# **WAIVER REQUEST**

## ***Monument Junction West Filing No. 1***

Waiver from Town of Monument Roadway Design and Technical Criteria:  
Appendix A, Table 5.2 Curb Return Radii

MONUMENT JUNCTION WEST FILING NO. 1
PUBLIC STREET IMPROVEMENT PLANS
STREET IMPROVEMENT PLAN & PROFILES

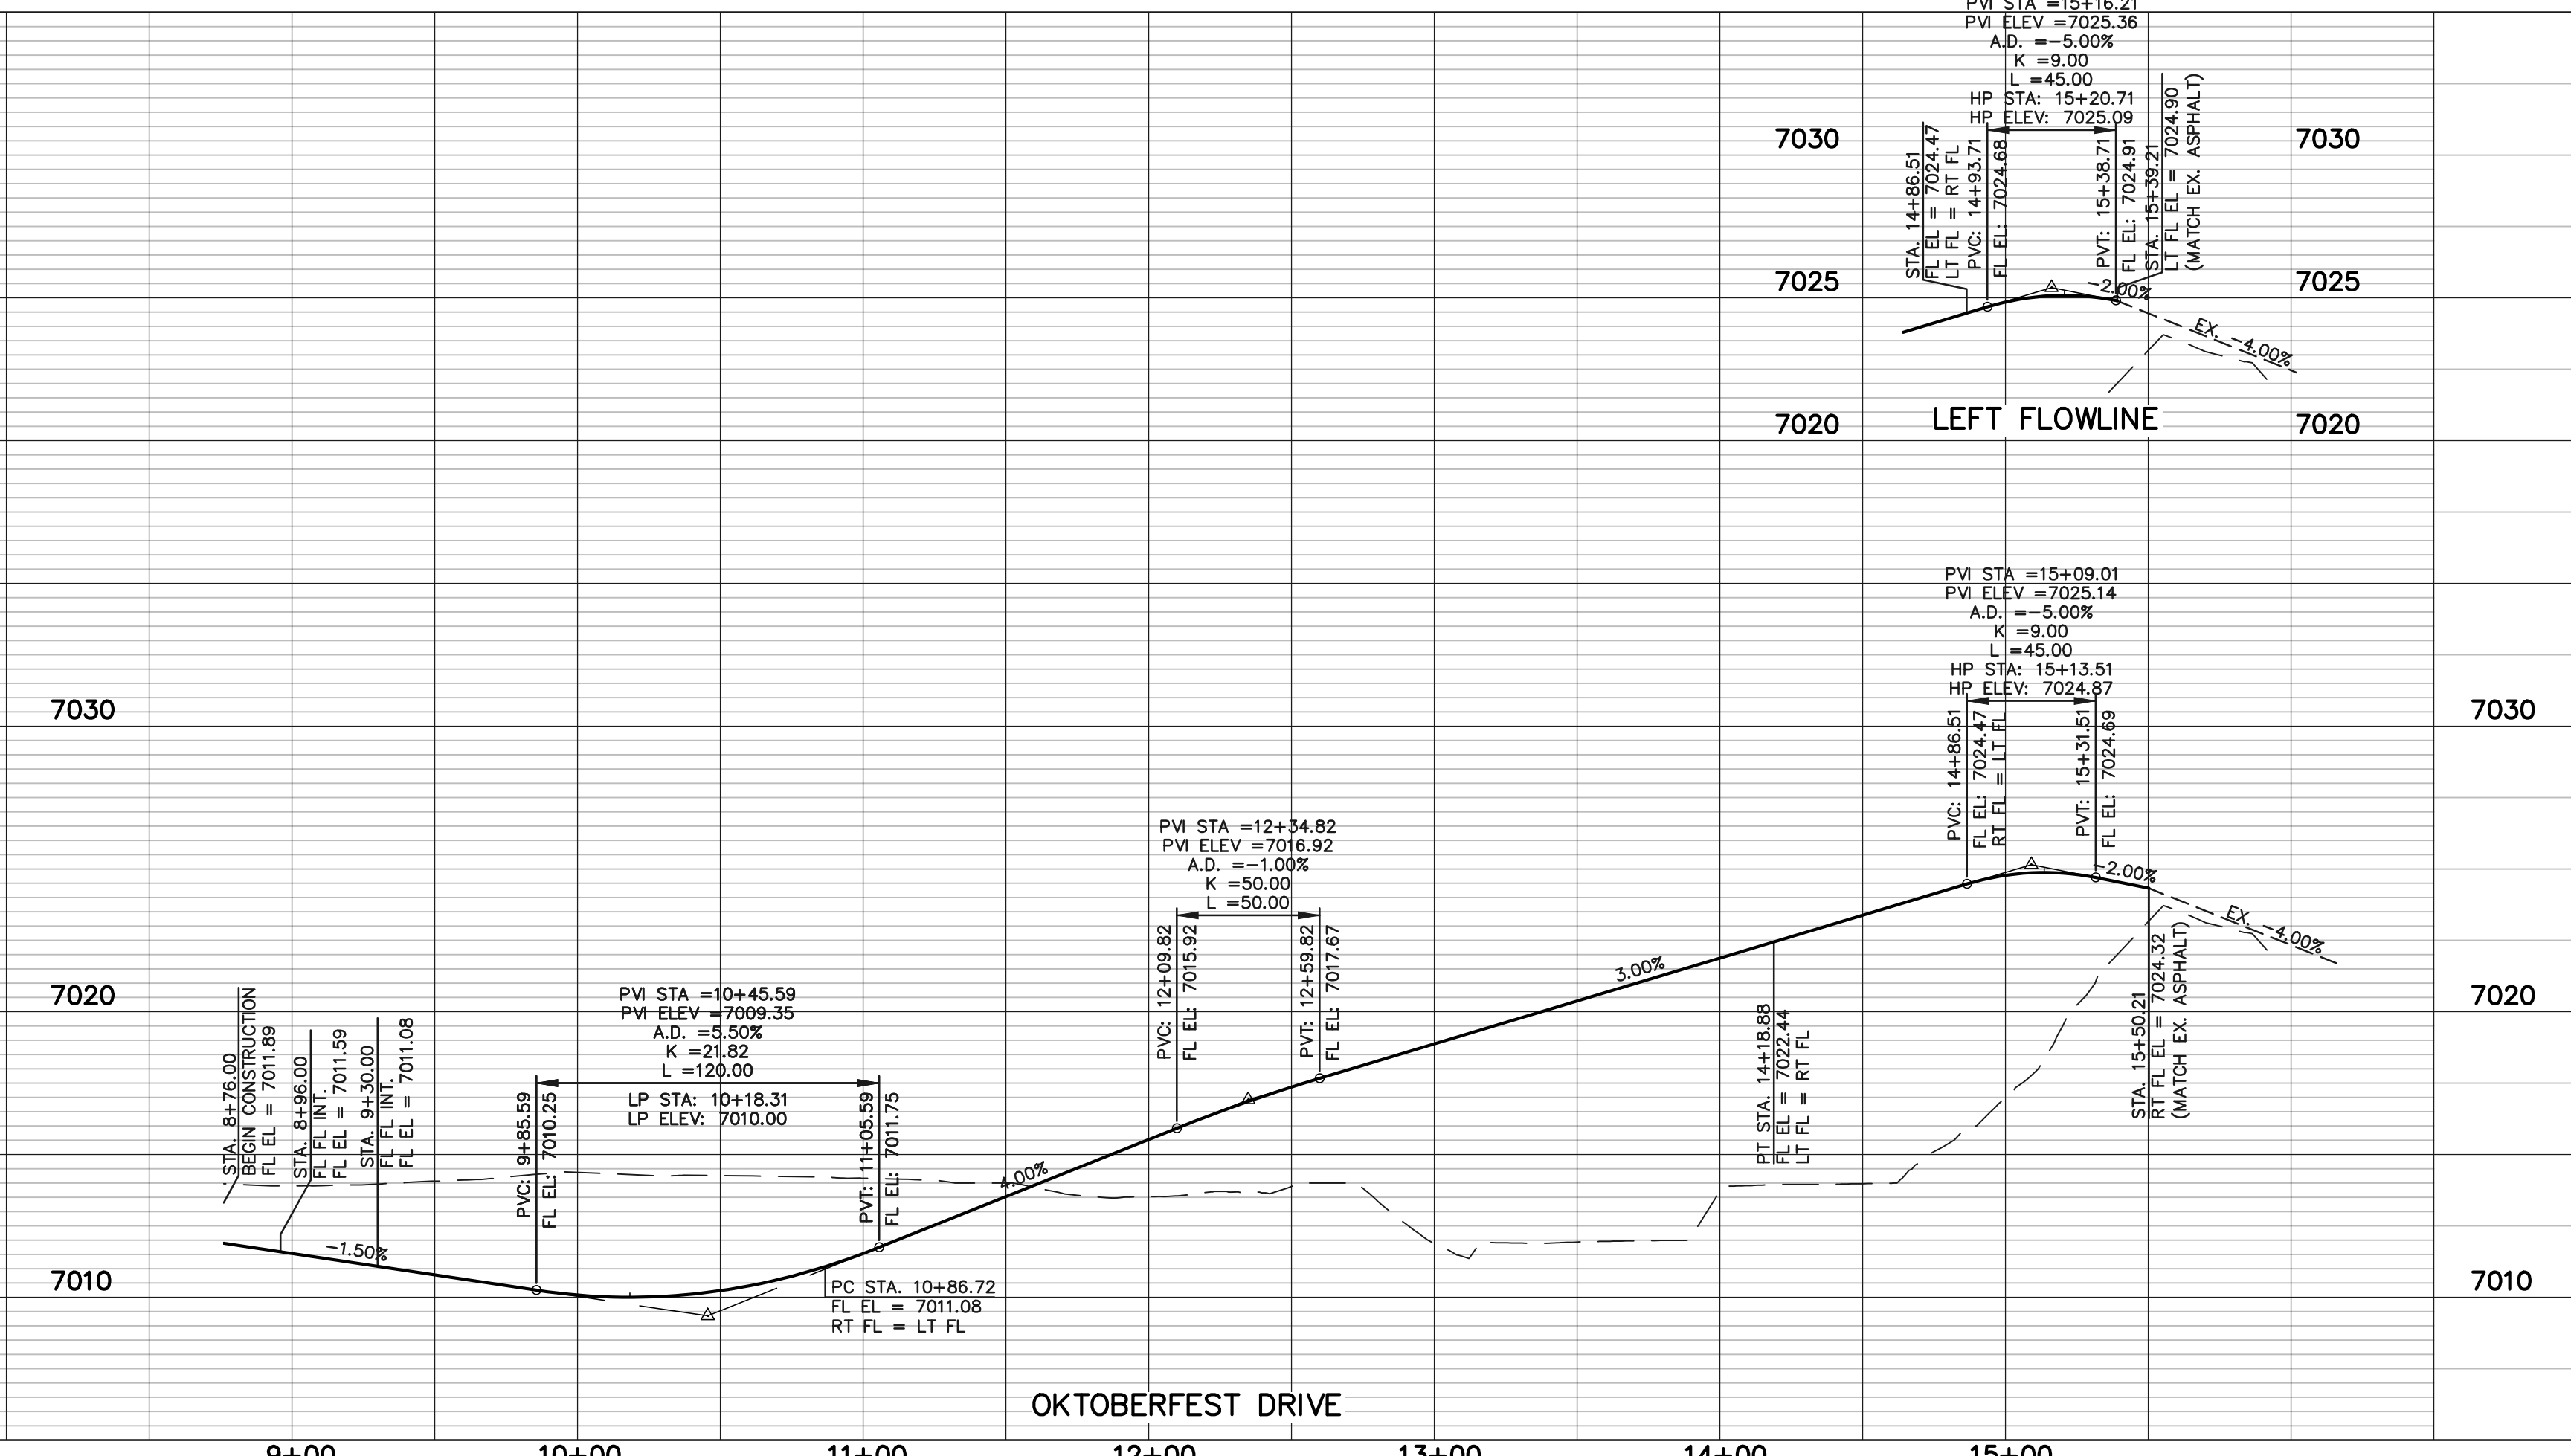
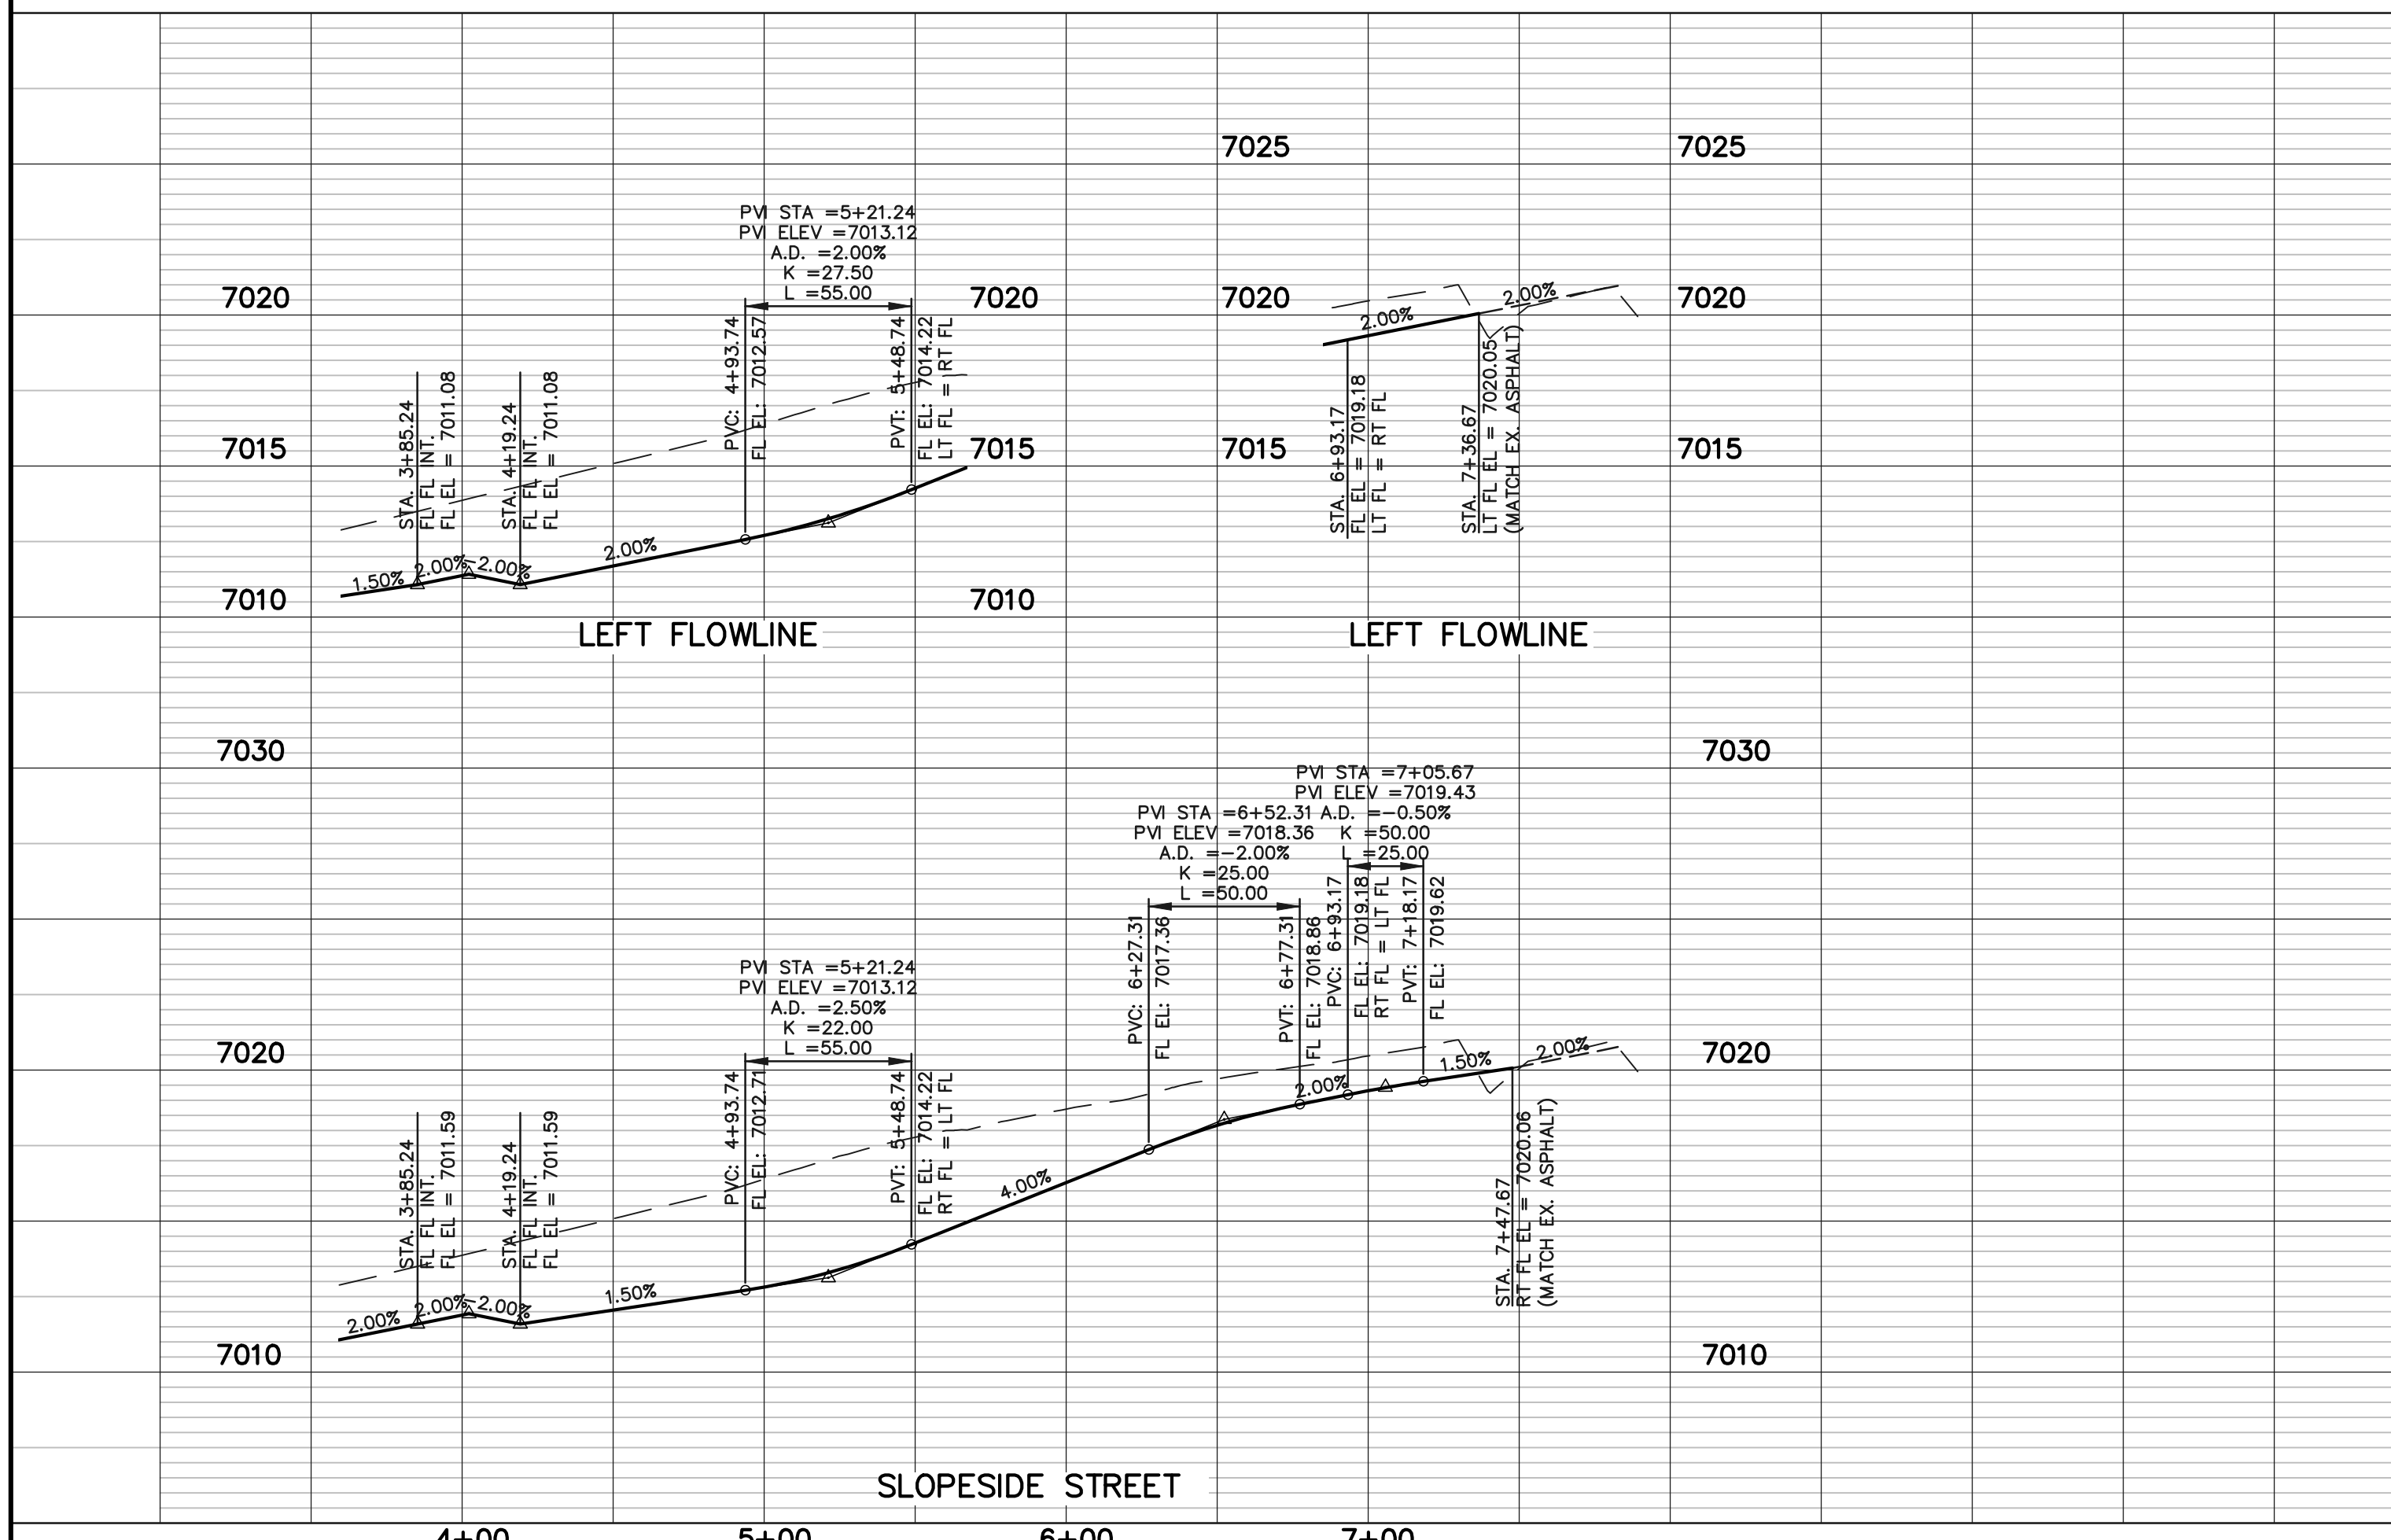
Criteria requires 30' curb return radii for Local roads intersecting Local roads  
Public street plans propose 20' curb return radii for Local - Local intersections

City of Colorado Springs criteria: 15' curb return radii for local roads

El Paso County criteria: 20 curb return radii for local roads

Appropriate Fire and truck access still provided
